From: David Senus <dsenus@woodardcurran.com>
To: Jean Fraser <JF@portlandmaine.gov>
CC: "DMP@portlandmaine.gov" <DMP@portlandmaine.gov>, "Barbara Barhydt(bab@portlandmaine.gov)" <bab@portlandmaine.gov>
Date: 12/11/2013 4:37 PM
Subject: Munjoy Heights Conditions of Approval
Attachments: Erosion and Sedimentation Control Plan_11-12-13.pdf

In reviewing the draft conditions of approval relative to site/stormwater issues, you do not need to include Condition #viii. under "Site Plan Review" - "That the applicant shall submit a more detailed Construction Plan to address the erosion impacts on neighbors during the construction period prior to the full installation of the stormwater drainage system". The Applicant has provided a detailed Erosion and Sediment Control Plan for the project as part of their mid-November submittal (see attached). This, in addition to the submitted Construction Management Plan; C-30 GRADING, DRAINAGE & EROSION CONTROL PLAN; and C-43 EROSION CONTROL DETAILS & NOTES sufficiently address erosion and sediment control practices and approach. They specifically address sequence of work to minimize impact on downhill properties.

DRAWING NO. **C-30**

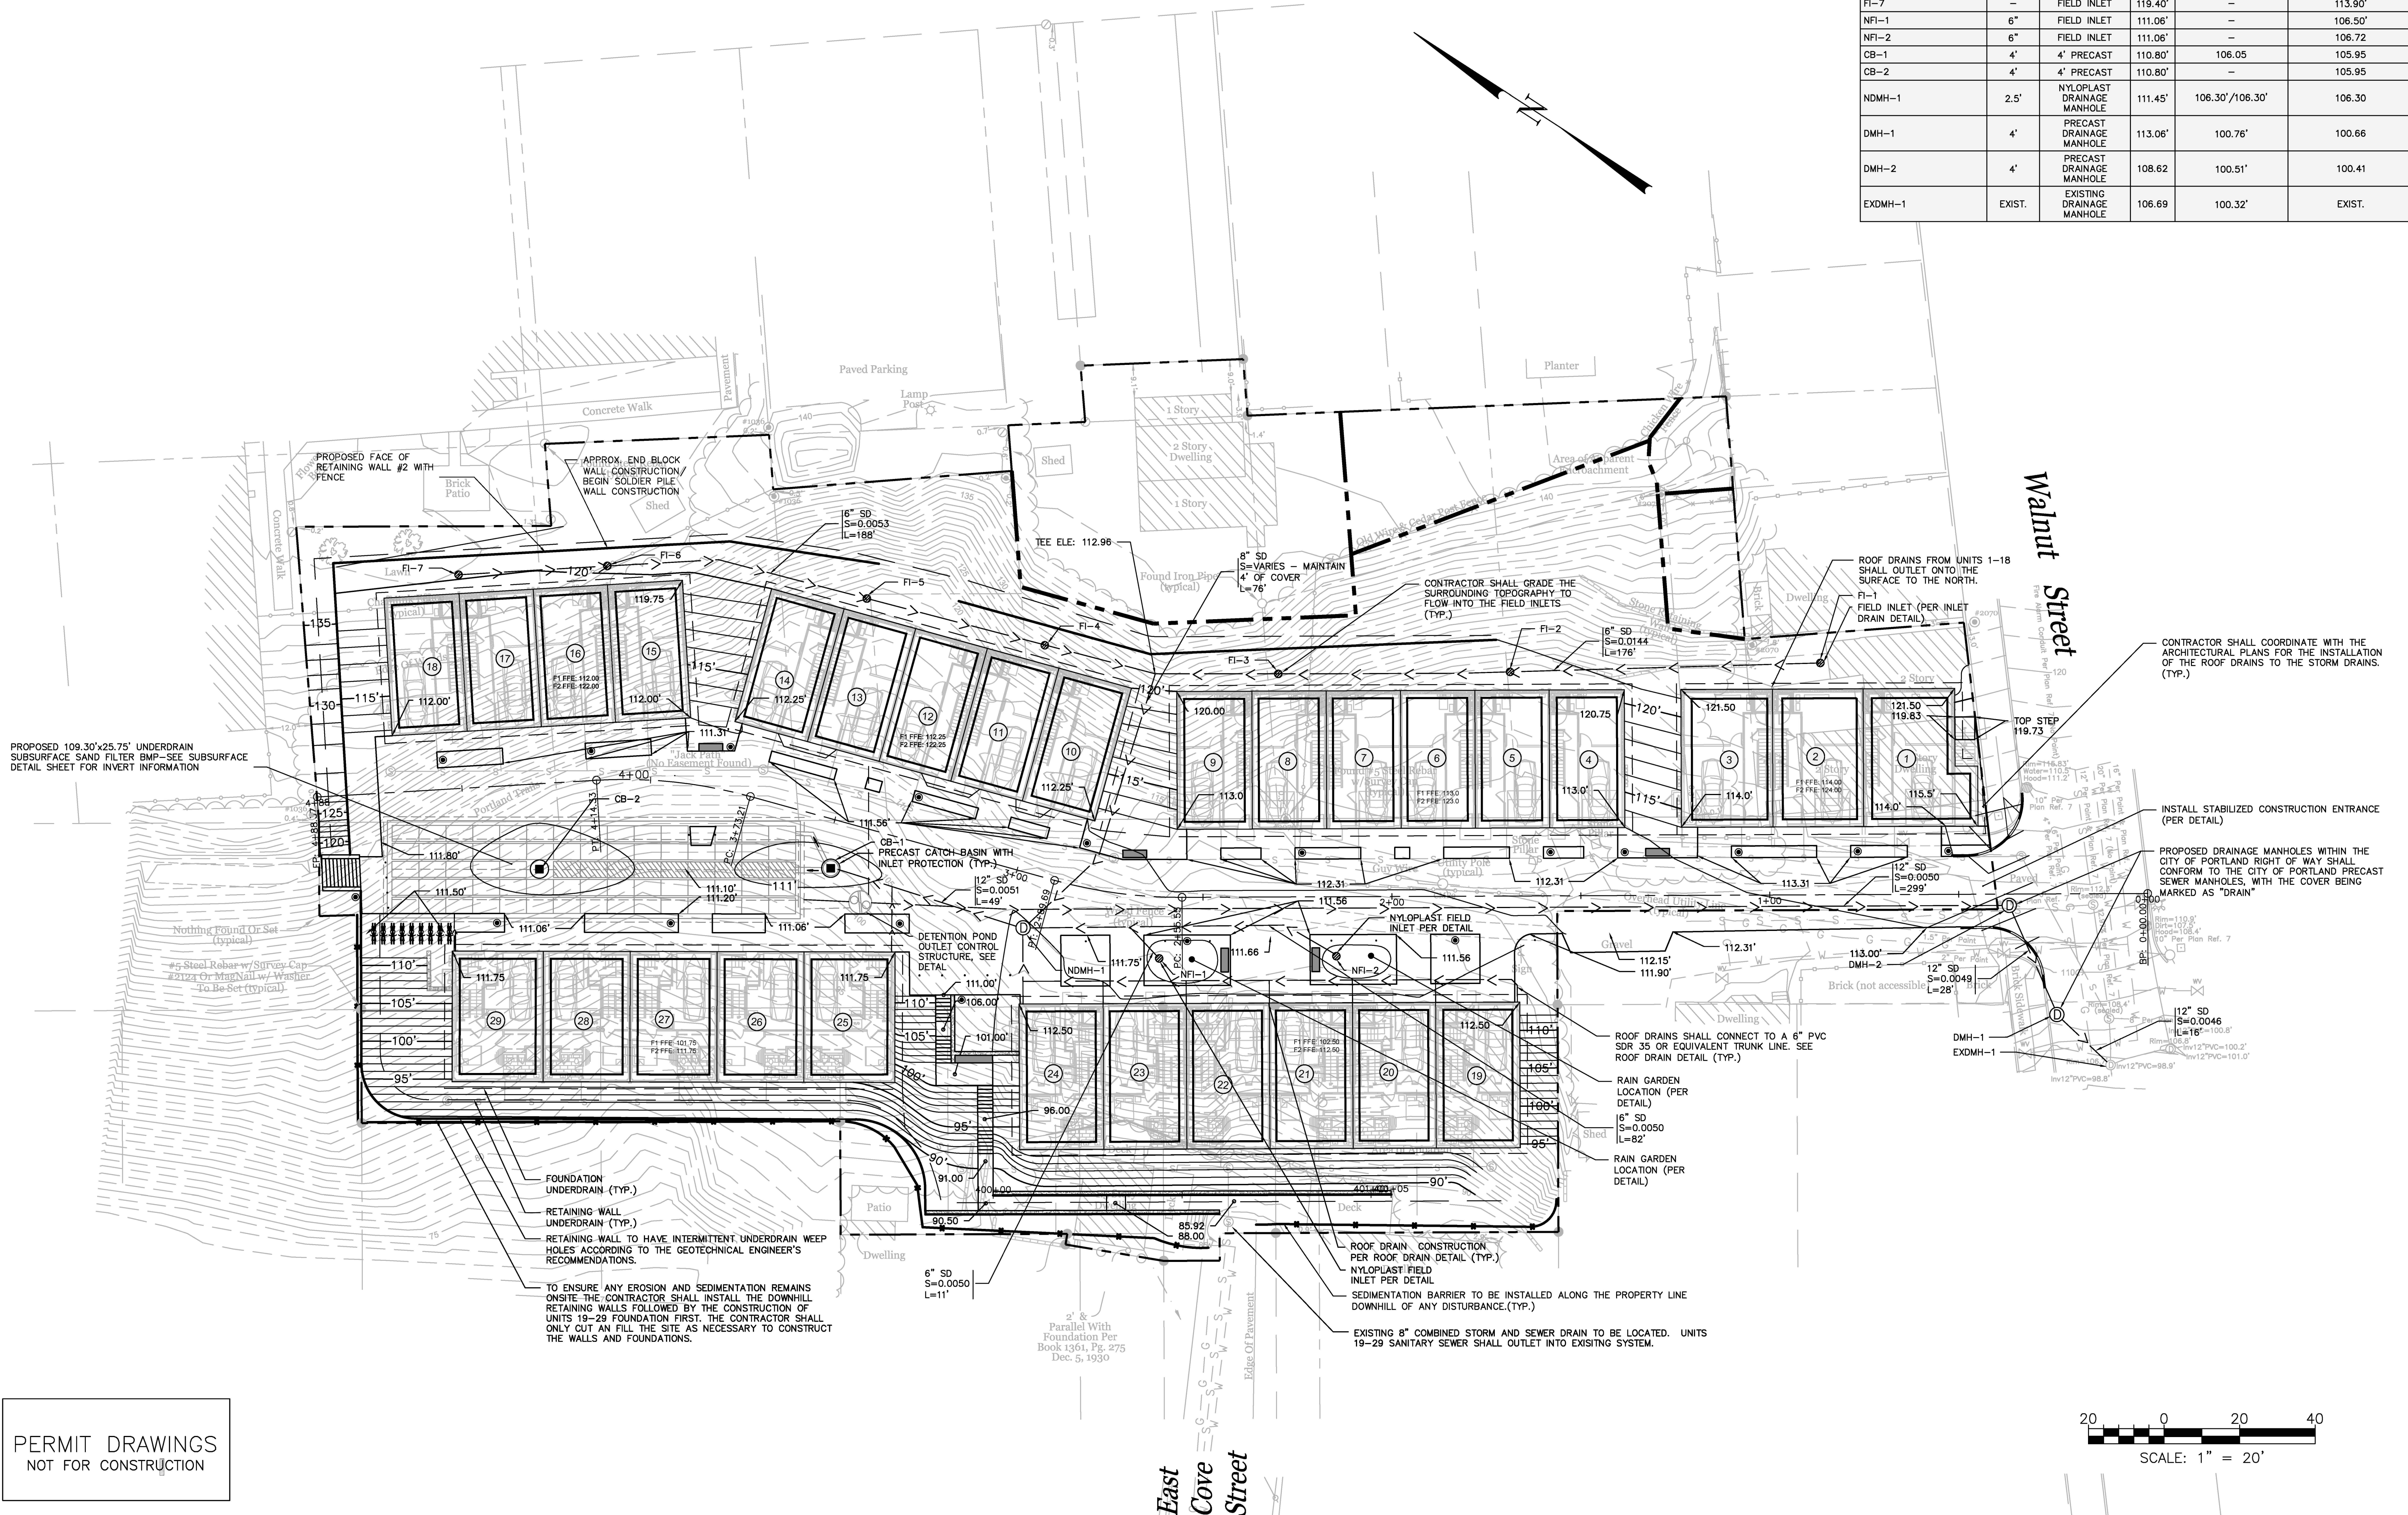
If erosion issues are evident during construction, the City can hold the applicant and their contractor to implementing the control measures identified in the plan.
